SUBJECT: SFD2206-0001
SINGLE FAMILY DWELLING

Here are the results of all Inspections located at **248 LAMBERT LN:**

**F1.0**

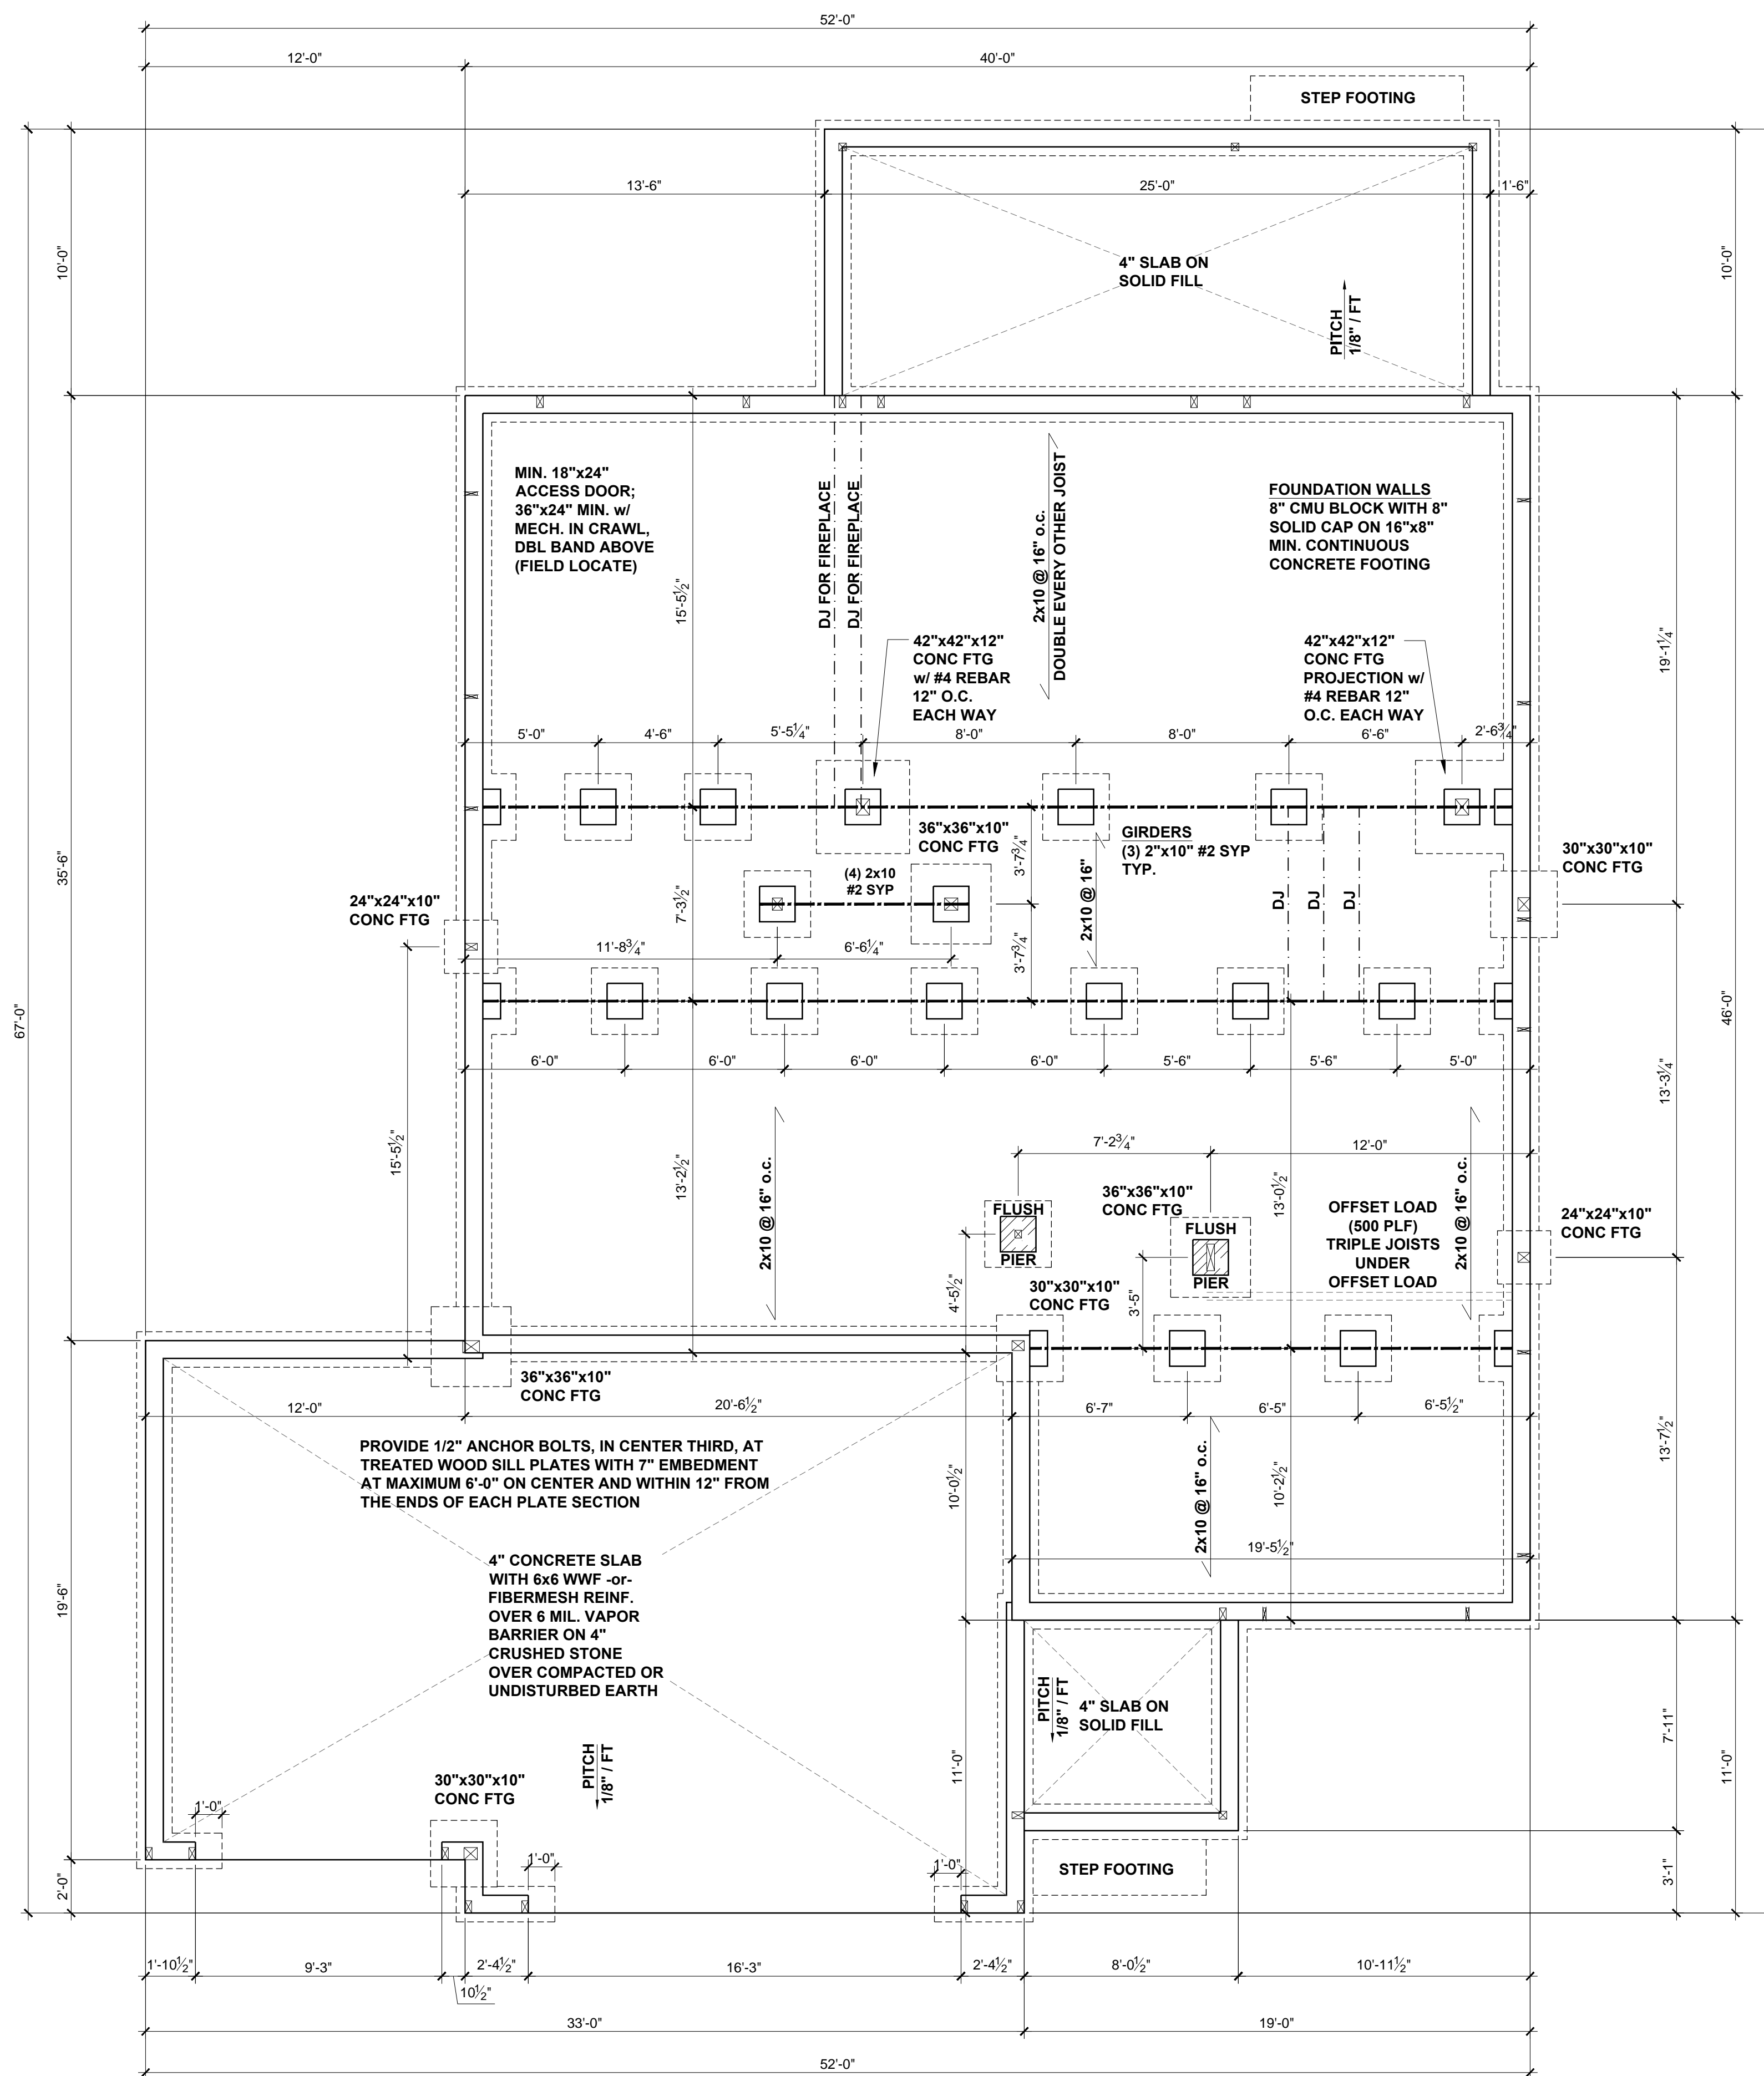
5 piers not in the center 1/3 of the footing (Marked on plans)

Piers that were not in center third have extension footing dug and rebar doweled in but not complete.
